From: Jonathan Best <Jonathan.Best@arun.gov.uk>
Sent: 25 March 2026 12:06
To: Planning.Responses <Planning.Responses@arun.gov.uk>
Cc: David Easton <David.Easton@arun.gov.uk>
Subject: A/34/26/DOC

Land North of Water Lane Angmering BN16 4EJ.

I have reviewed the approval of details reserved by condition under A/248/21/PL relating to condition 11- Schedule of Works (based on the recommendations within the Preliminary Ecological Appraisal Report).

Figure 11. Phoenix Southwold Bird Box, 50no. to be integrated into buildings (Phoenix Building Products, n.d.)

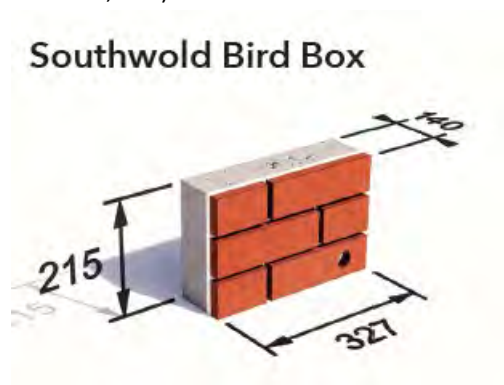
The proposed Phoenix Southwold Bird Boxes do not provide supporting evidence they are suitable for swifts. Consideration should be given to increasing the number of Swift bricks to a ratio of 1:1 as supported by national planning guidance and best practice. It is worth noting that provision of swift bricks was not included in the 2018 ecology partnership PEAs recommendations.
